City of Albuquerque  
Stormwater Construction Site  
Inspection Report

Project Name and Location	murphy Express 1358 Wyoming Blvd NE		
Site Contact Name & Agency	Shawn Cook JMD Construction	ESC File No. NPDES ID No.	J20E037
Date of Inspection	1-11-19	Start/End Time	12:45/
COA Inspector Name	Curtis Cherne, Stormwater Quality		
Describe Present Phase of Construction	bldg exterior complete, installing landscaping		
Type of Inspection:	<input checked="" type="checkbox"/> Regular <input checked="" type="checkbox"/> During storm event <input type="checkbox"/> Post-storm event (> 0.25 inch) <input type="checkbox"/> 311 / Complaint Response <input type="checkbox"/> Follow-Up

SHEET NO. **C-4.1**
 JOHN H. NOURDAD
 NEW MEXICO
 PROFESSIONAL ENGINEER
 11/15/17

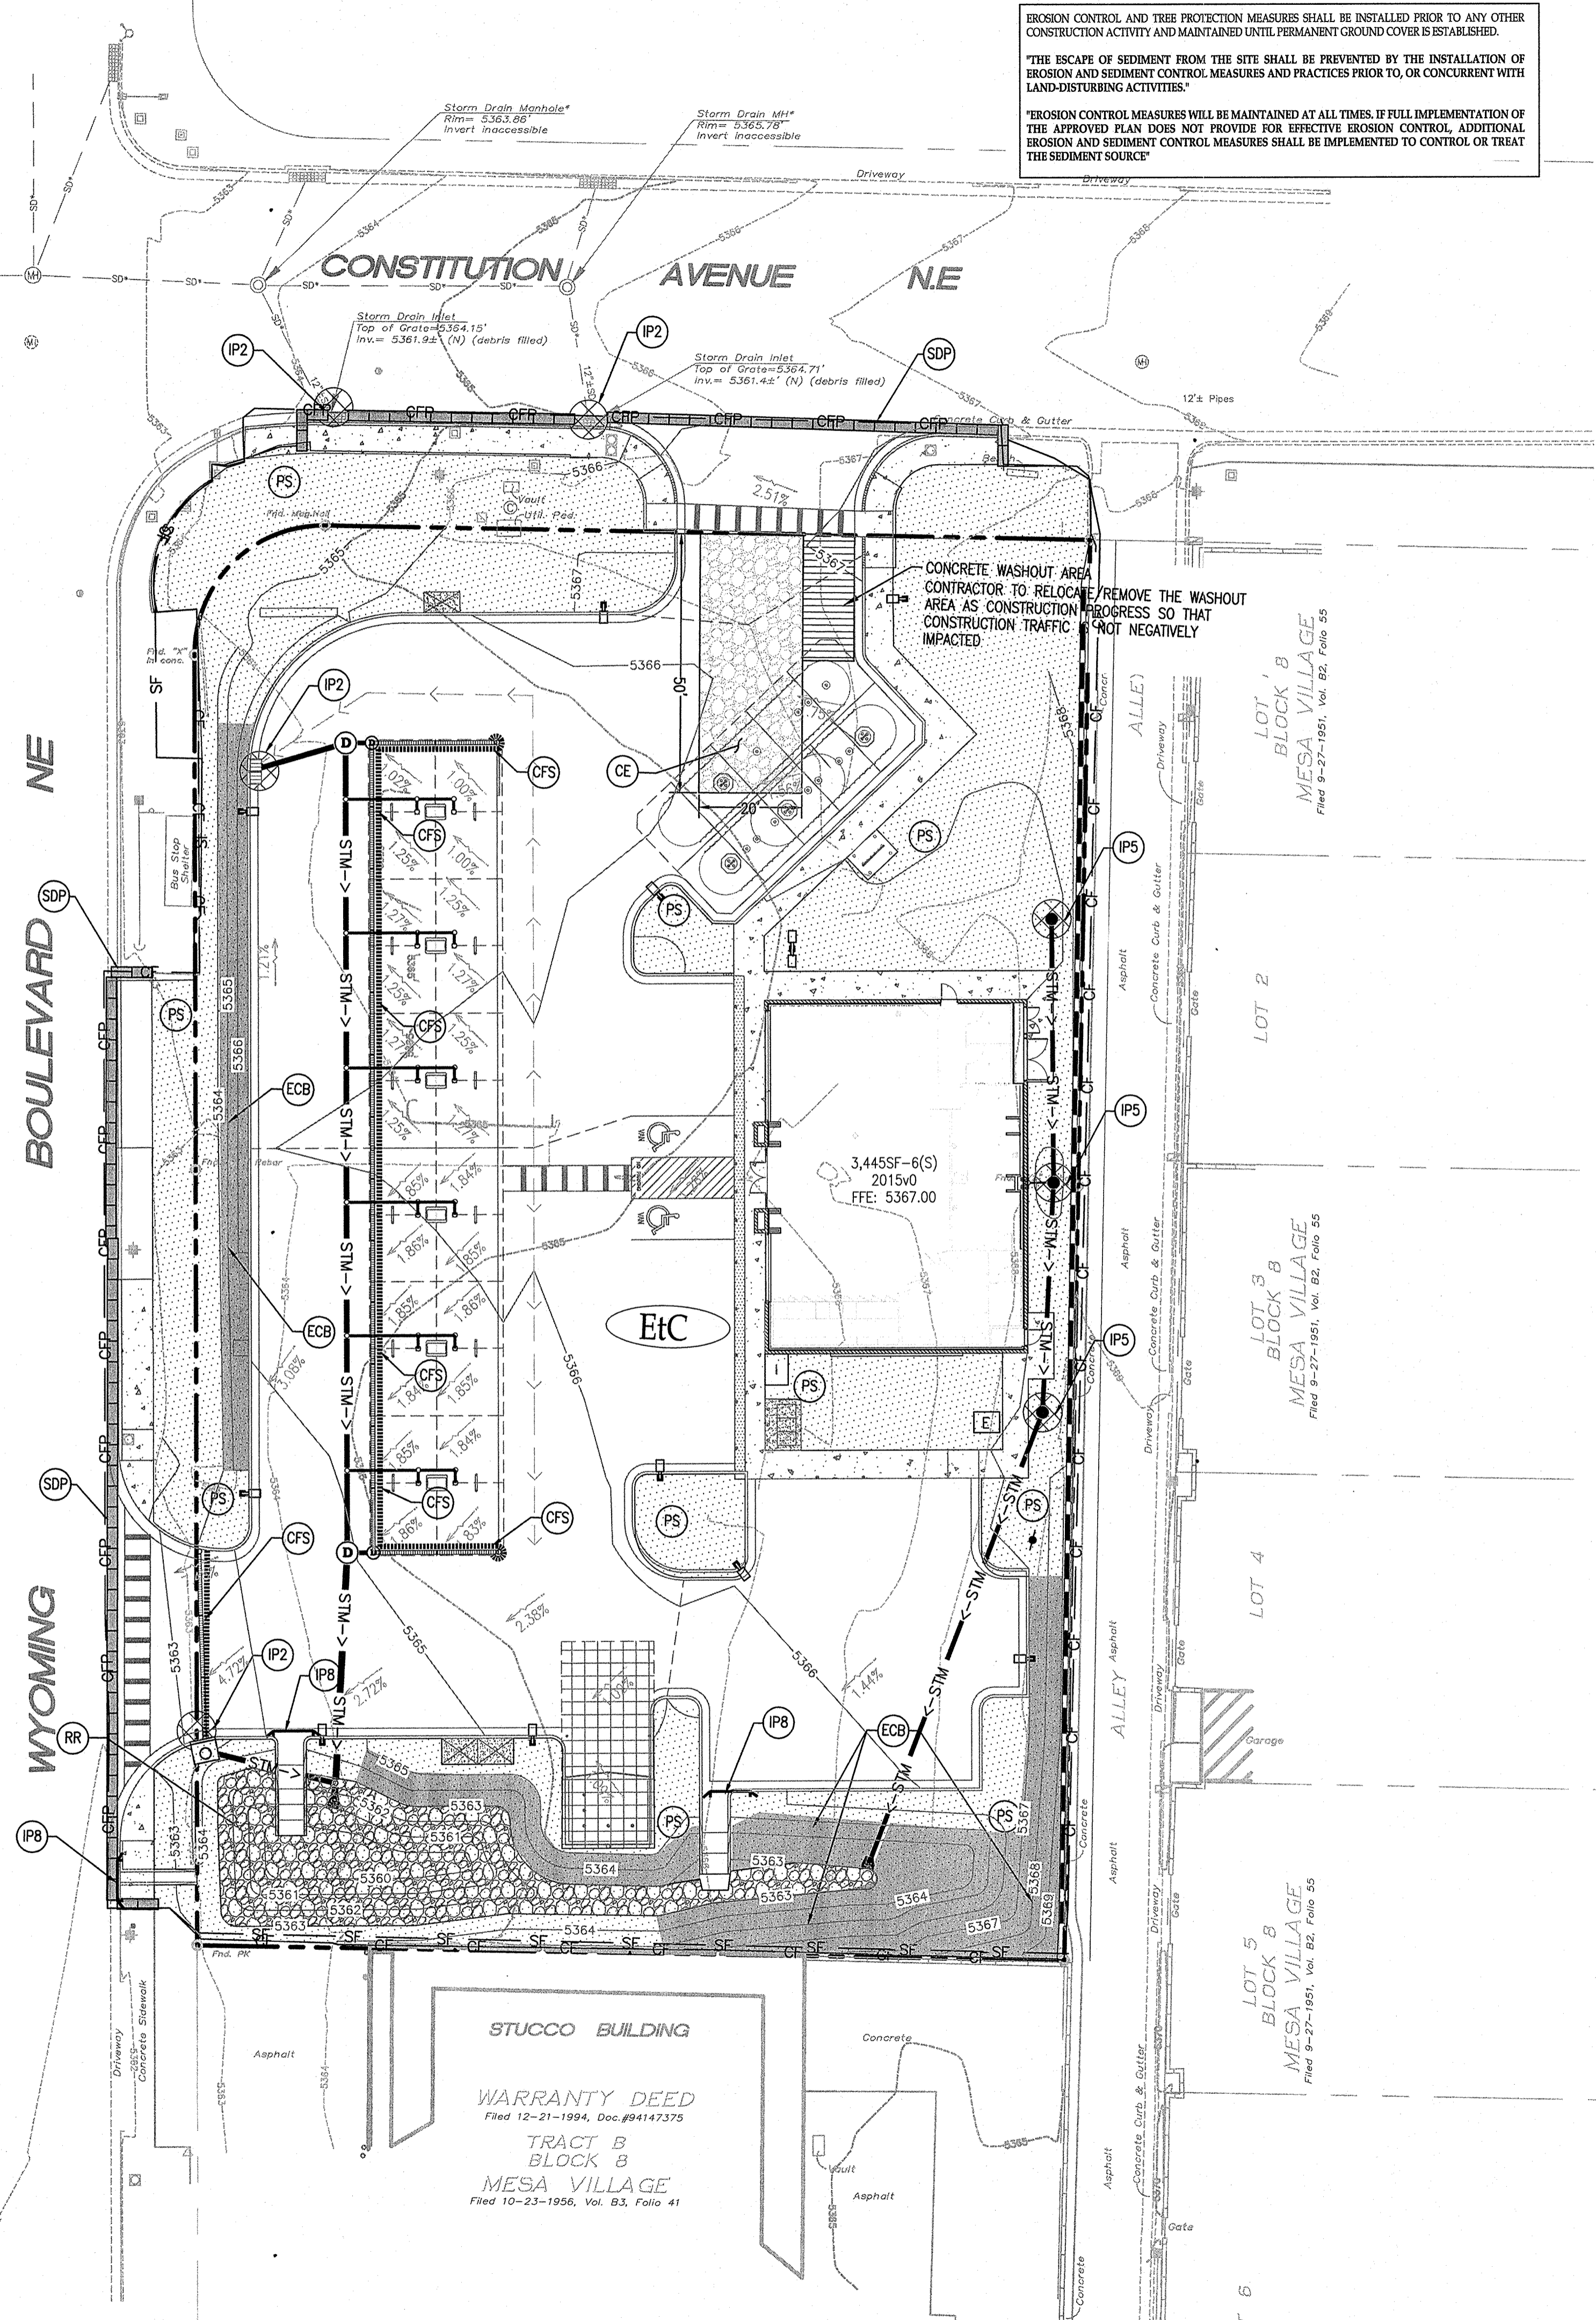
CGP <sup>1</sup> Section	BMP / Activity	Maintenance or Corrective Action Required	Location and Notes
1.5	Post a Notice		
2.2.1	Provide and maintain Natural buffer when Waters of the US < 50 ft		
2.2.3	Sediment control along any perimeter	✓	Sediment on drive apron and gutter
2.2.3	Sediment control along any perimeter	✓	<del>no sediment BMP NW corner installed</del>
2.2.3	Sediment control along any perimeter		
2.2.3	Sediment control along any perimeter		
2.2.3	Sediment control along any perimeter		
2.2.3	Sediment control along any perimeter		
2.2.3	Sediment control along any perimeter		
2.2.4	Minimize sediment track-out

2.2.5	Manage stockpiles		
2.2.6	Minimize Dust		
2.2.10	Protect Storm Drain Inlets	✓	<del>no inlet protection</del> installed
2.2.10	Protect Storm Drain Inlets

2.3.3	Building Material Storage		
2.3.3	Fuel, oil, hydraulic fluid, petroleum products and chemical storage		
2.3.3	Construction and Domestic Wastes	✓	dumpsters not covered / no ability to cover

2.3.3	Construction and Domestic Wastes	✓	trash Debris NW corner
2.3.4	Washing Applicators used for paint, stucco, concrete, etc.		
2.3.4	Washing Applicators used for paint, stucco, concrete, etc.

Maintenance or corrective actions are to be completed within 7 days.
